Rezoning Petition Review

Rezoning Petition #: 20-165

Location of Property: Approximately 6.99 acres located east of the intersection of Mt. Holly-Huntersville Rd and Beatties Ford Rd

RZ1.00

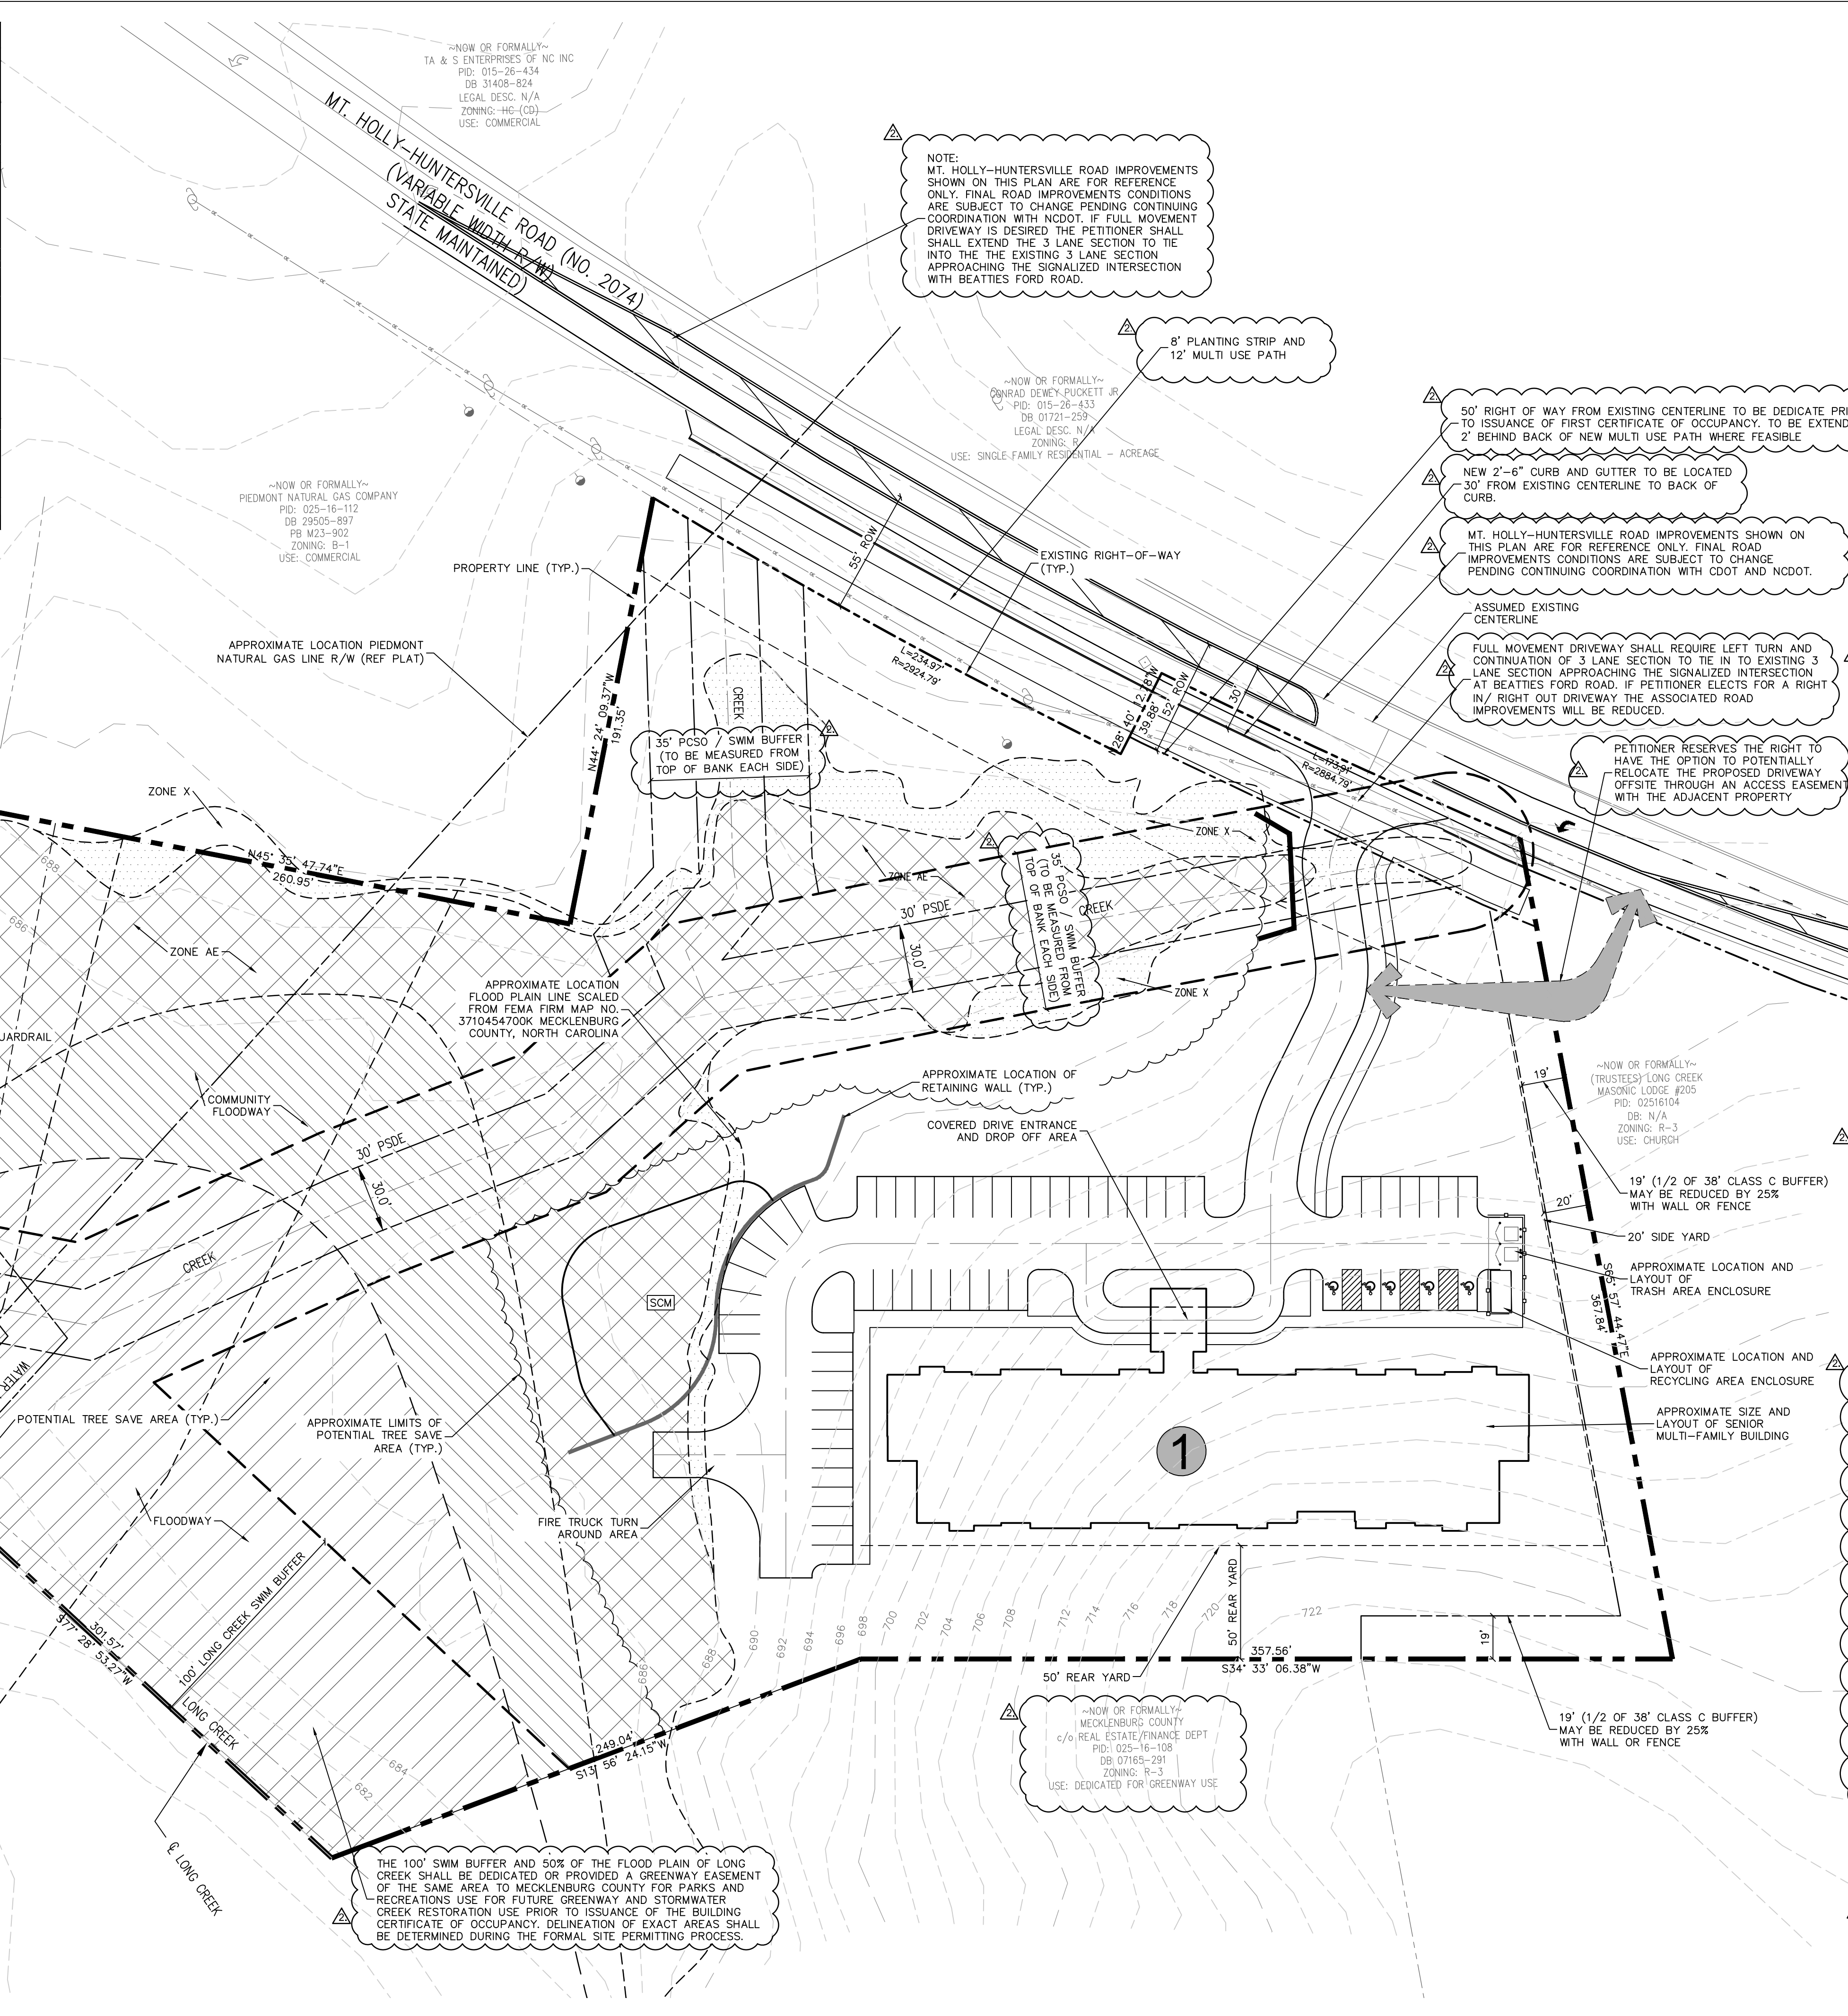
Environmental: Stream/wetland survey required prior to approval of civil site plan to ensure accurate delineation of top-of-bank/stream buffers/creek path and identification of any protected wetlands that may be on the site.
